Martin Nugent
01254 828060
D3/12/0879

**Planning Application, Ribble Valley District
3/12/0879 The Stables, Duck Street, Clitheroe**

I am recommending refusal of this application on highway safety grounds.

Description  
Site Location

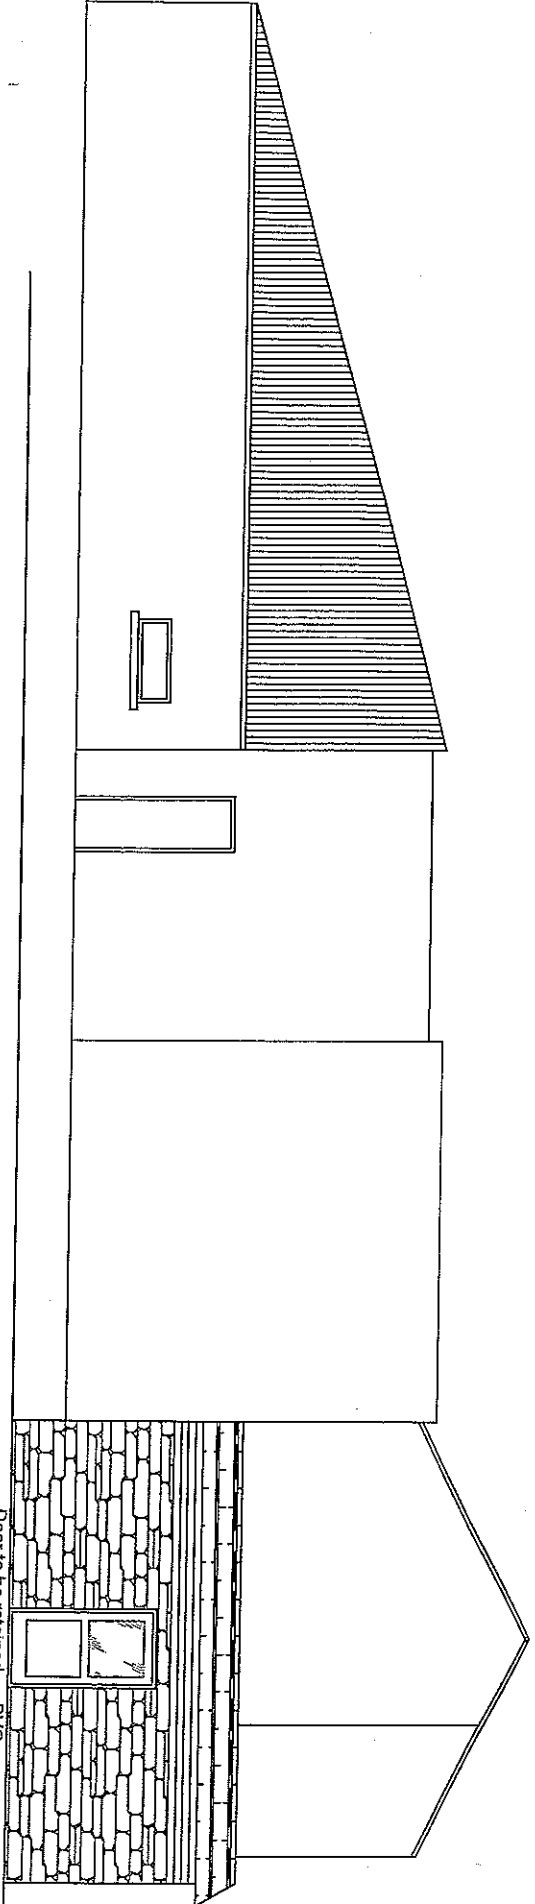
The only designated off street parking space identified by the applicant is the one space that runs along the south east gable end of the proposed office space. I am satisfied that this is an appropriate level of provision for this aspect of the development.

However, the route to the workshop from Duck Street utilises a ginnel that also provides access to the rear of residential properties No. 8, 10, 12, 14 and 16 Duck Street.

In addition, there is insufficient manoeuvring space available within the approaches to the workshop to allow a commercial vehicle to enter and leave the site in a forward gear. Therefore, there would be the potential for reversing to and from the highway on a more regular basis and by a different vehicle type than occurs at present.

This problem is exacerbated by the poor visibility available for motorists emerging from the back ginnel and the narrow and discontinuous footway provisions immediately adjacent to the access. This would introduce an additional hazard to safe pedestrian movement on the south east side of Duck Street.

I am recommending refusal of this application on highway safety grounds as I am satisfied that as a result of the combination of proposed uses, in particular the inappropriate servicing available for the development of the workshop area, the anticipated vehicular activity in this immediate vicinity would be detrimental to highway safety for pedestrians and other road users.
